Cory Decarbonisation Project

Responses to Deadline 1 and Deadline 2 submissions on behalf of Landsul Limited and Munster Joinery (U.K.) Limited

Expert Report

Supplementary Report for Deadline 3

Alternative Site Layout

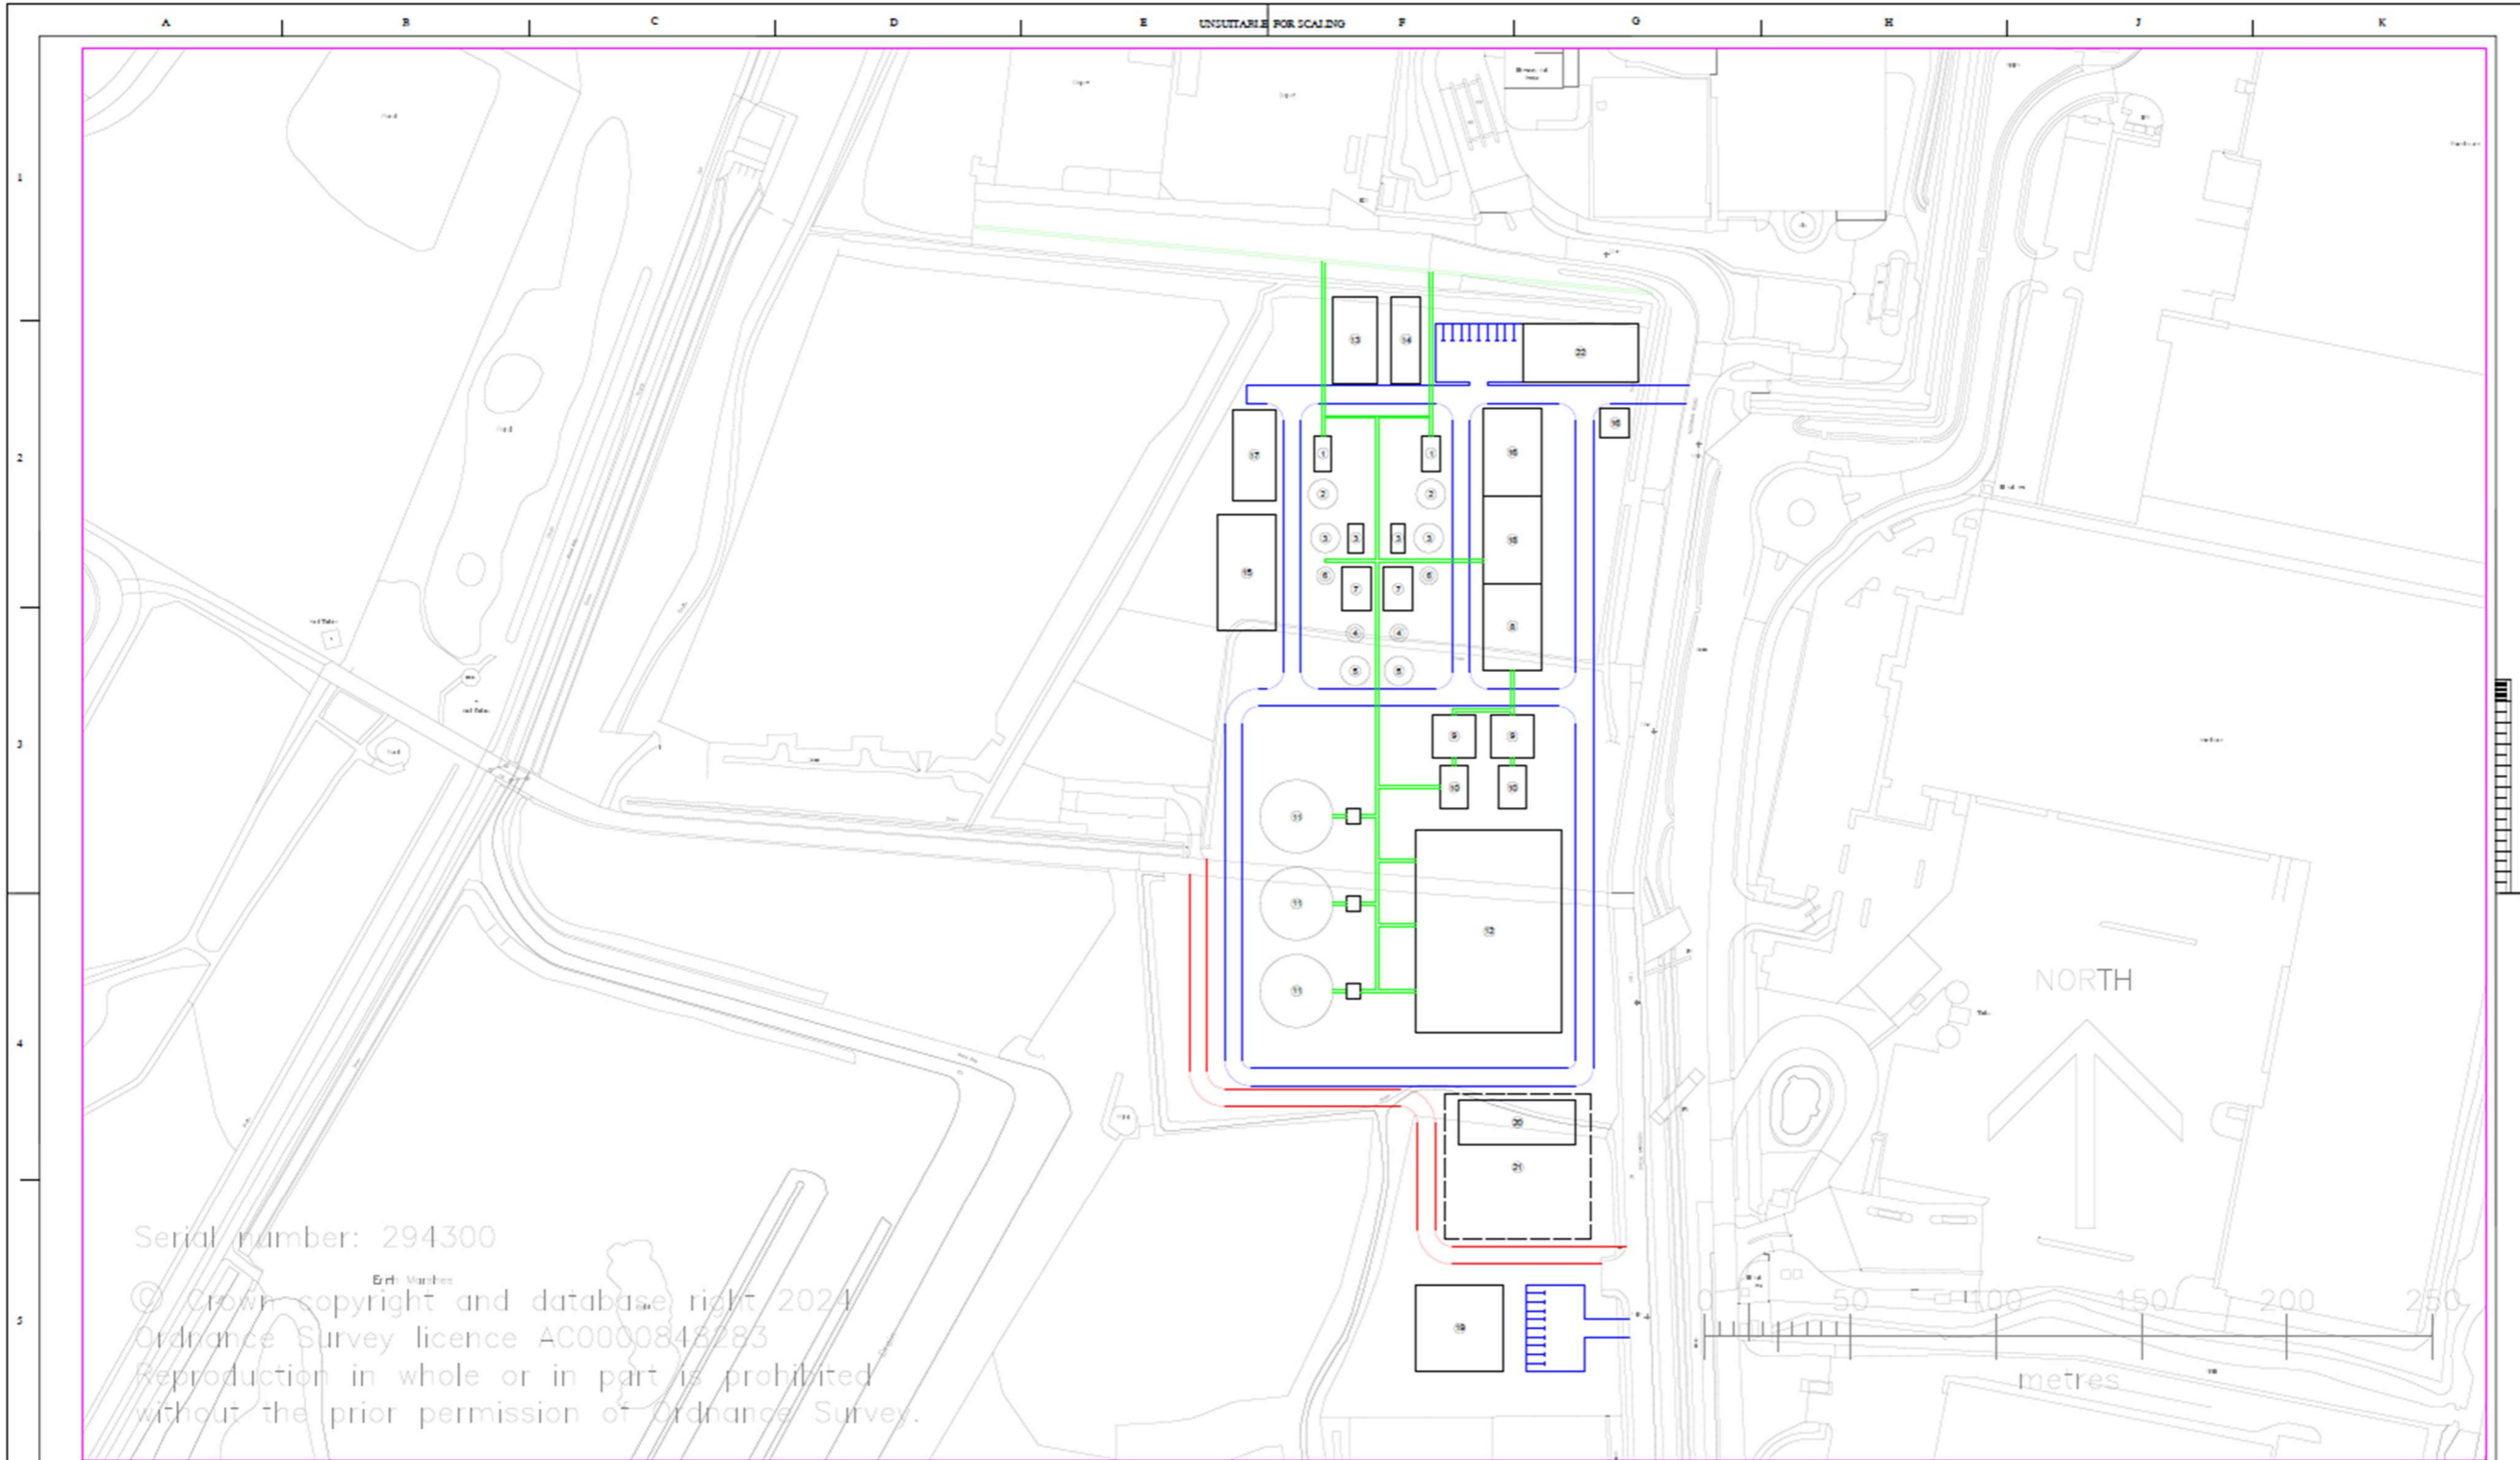
2.1 I have included an updated Alternative Layout in appendix A. The key differences to the previous layout (which I will discuss in more detail below) are:

- (a) The Heat Transfer Station (HTS) is now a fully segregated facility to match the Applicant's proposal.
- (b) The liquid CO₂ storage tanks have been relocated further away from Norman Road to address concerns raised by the Applicant in respect of their previous location in the Alternative Layout.
- (c) The water storage tank is now an underground tank to match the Applicant's proposal.
- (d) The Welfare Facilities and Control room have increased in size to match assumptions given by the Applicant.
- (e) The footprint for the cooling towers has been changed to match that of the Applicant.
- (f) The Water Treatment Plant footprint has been changed to match that of the Applicant.
